September 8, 2023

Re: **ALLSUPS #102460**
Project #: PR-2021-006208
Application #: SI-2023-01171

Please find the following responses addressing comments received in a letter dated August 1, 2023. In an effort to address your comments concisely and simplify your review of these development plans, we have summarized your comments and our responses below. Your comment is listed first, followed by the response in Bold.

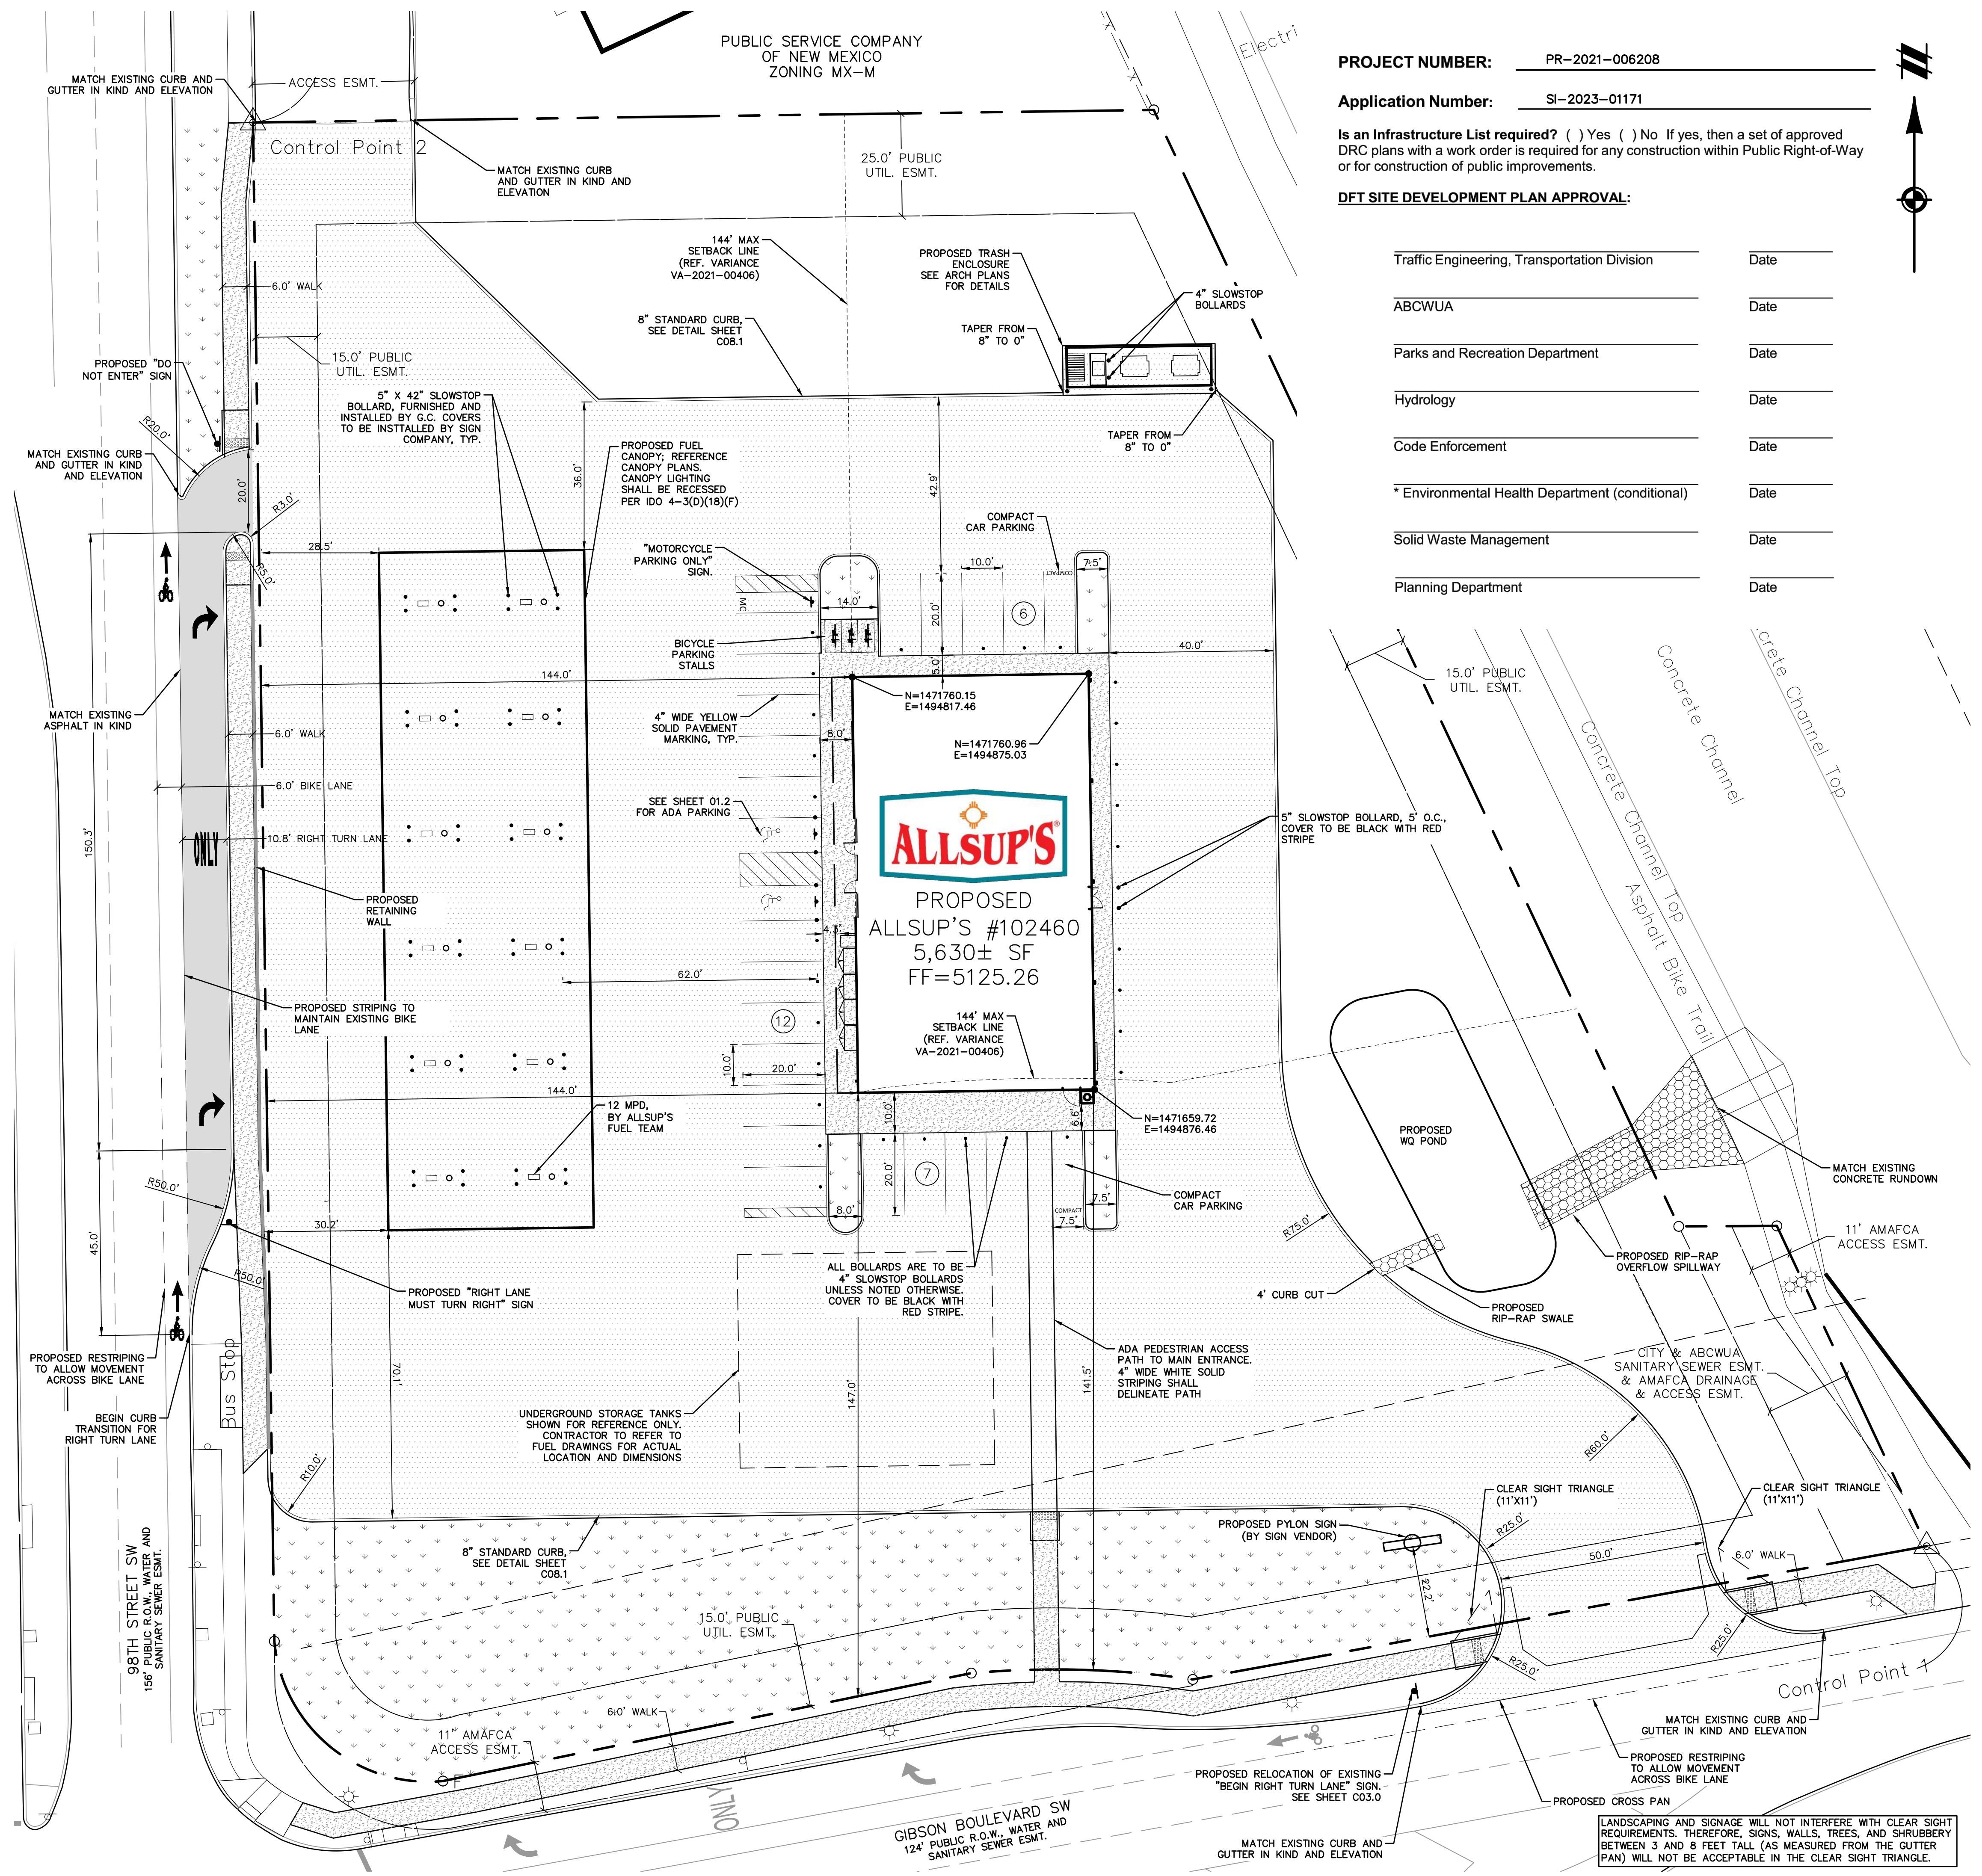
Comment 1: **IDO 2-4(D) MX-M Moderate Intensity Zone:** Dimensional standards and setbacks must IDO zone. Zoning variance needed for front setback.

Comment 24: A DFT signature block must be added to the Site Plan.

Comment 25: The project and application numbers must be added to the Site Plan first page.

Comment 4: Please confirm and note in site plan that lighting under canopy will be recessed as per IDO 4-3(D)(18)(f).

Response 1: The approvals were originally approved on December 21, 2021 (VA-2021-00406). There was an extension that was approved until January 5, 2024 for the listed applications. Attached to the resubmittal is the original approval and the extension document.

Response 24: DFT signature block added to site plan.

Response 25: Project and application numbers have been added to site plan.

Response 4: Confirmed and note added to site plan on canopy directly.
